Proposed modification of the Fraser Drive Residential Subdivision (MP 06_0243 Mod 5) at Lot 2 DP 1000385 & Lot 212 DP 1231622 & Lot 9 DP 1039569; Fraser Drive TWEED HEADS SOUTH

I refer to Department's invitation for Council to provide comment on the proposed modifications (Mod 5) of the Fraser Drive Subdivision. Upon review of the modification application, please find below Council's comments:

TYPICAL ROAD CROSS SECTIONS

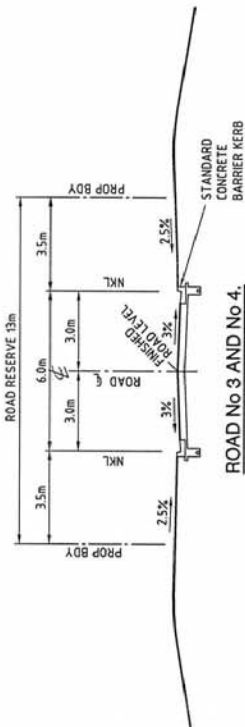
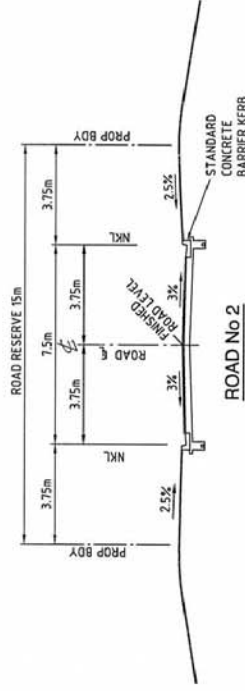
The cross sections proposed for Road 3, 4 and 6 are in accordance with Tweed Shire Council standards for width and gradients. However, no typical sections are provided for Road 5 and Ocean Avenue Extension.

FIGURE No.DA 20
POST DEVELOPMENT
STORMWATER NETWORK

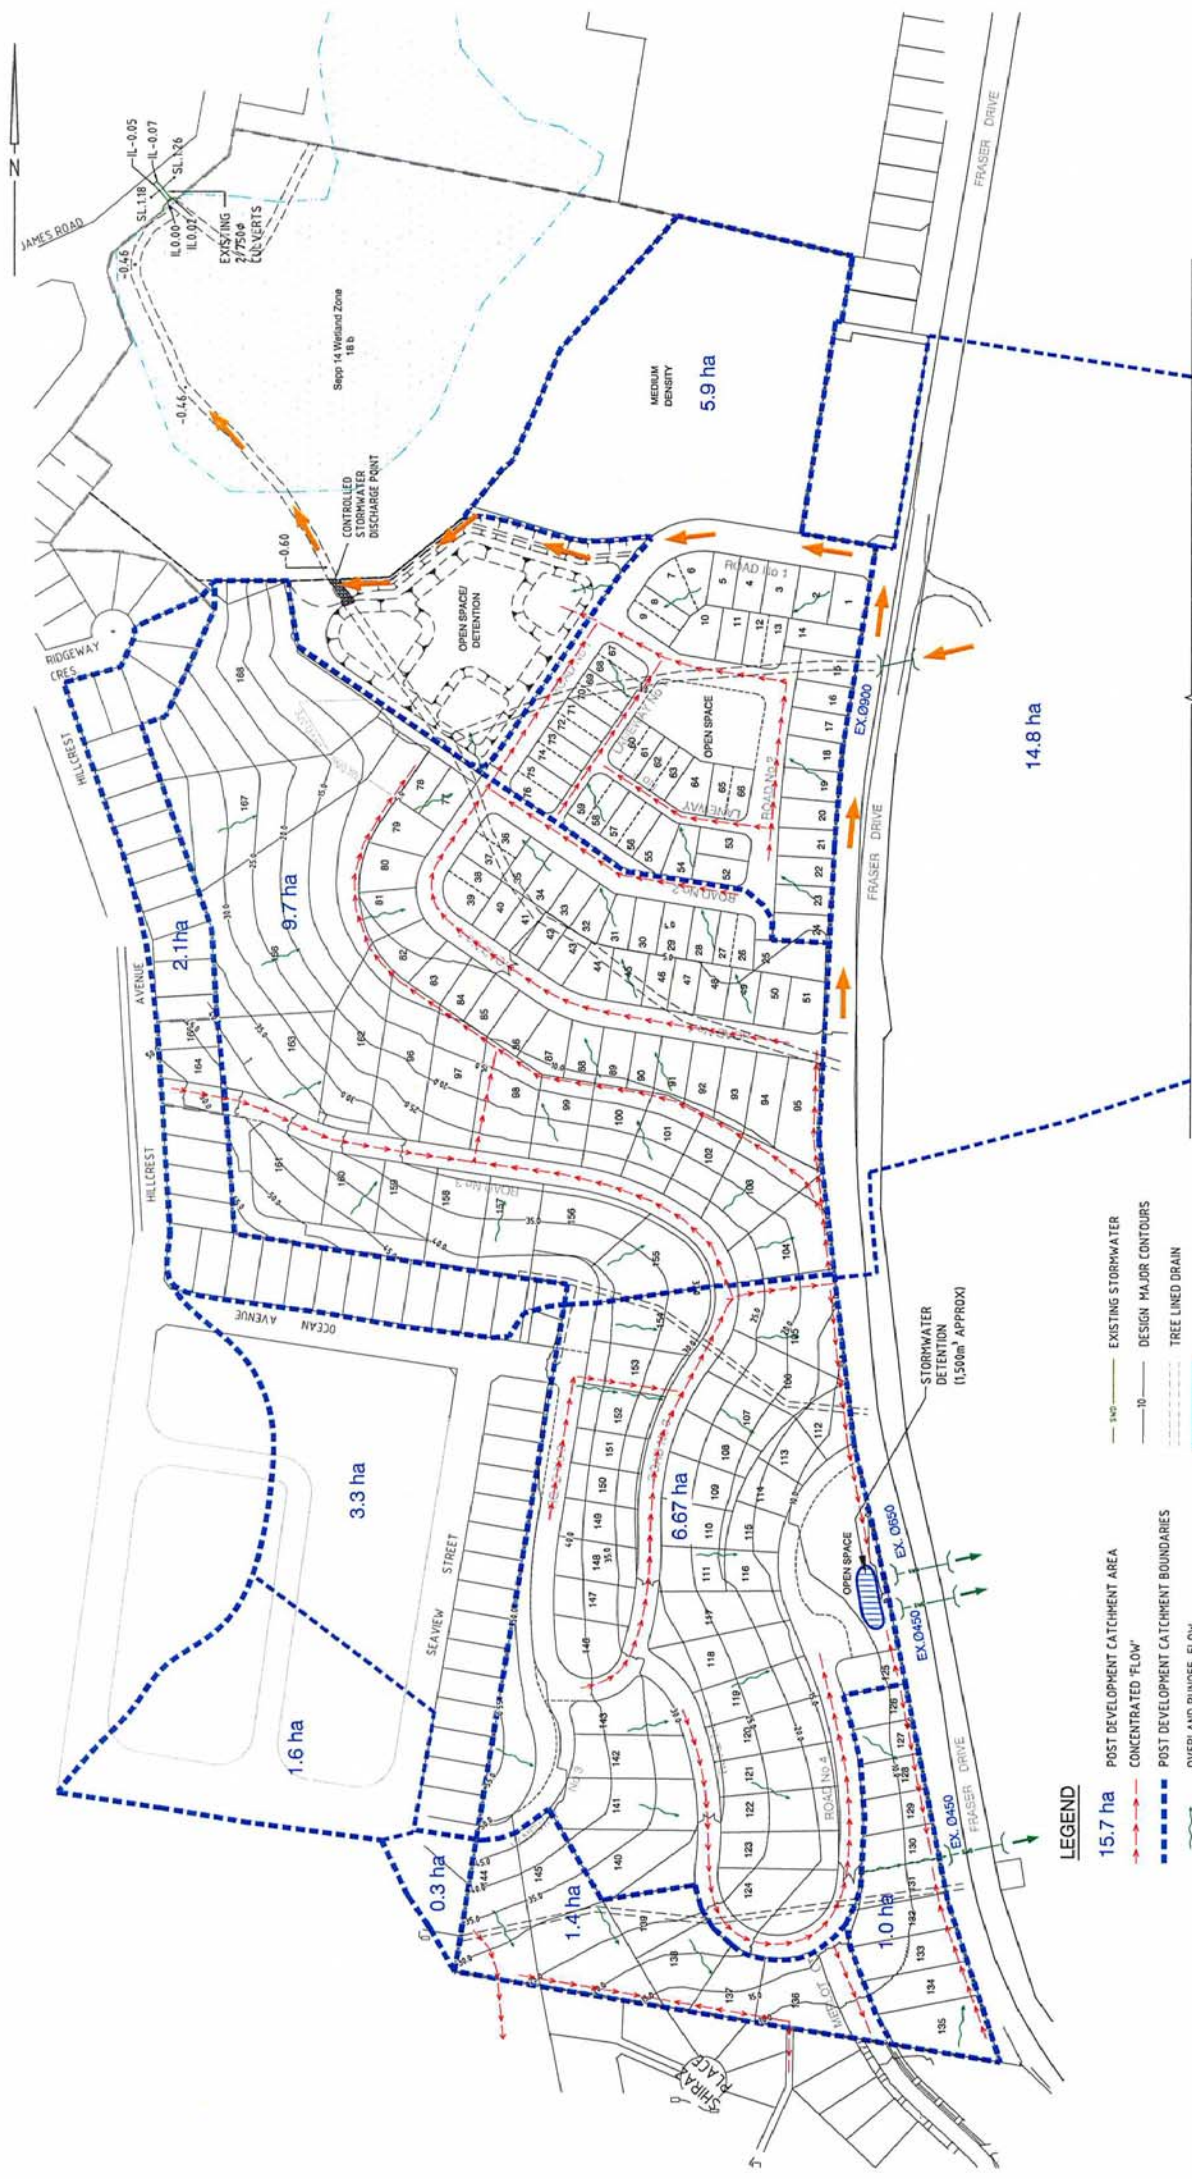
Concerns are raised regarding overland flow paths. The Mod seems to be reliant on road piping only. Overland flow should have its own dedicated parcel of land and not through properties. The land at end of Road 5 should be overland flow path and not an easement through private property. The proponent should re-visit overland flow paths to ensure properties are not affected in major storm events.

To be effective, the proposed onsite-detention system must have all major flows directed into the basin. No detail has been provided on how overland stormwater flows will be accommodated and managed within the site. The additional proposed lots and increased number of lots with adverse fall increase the risk of overland stormwater flooding of properties.
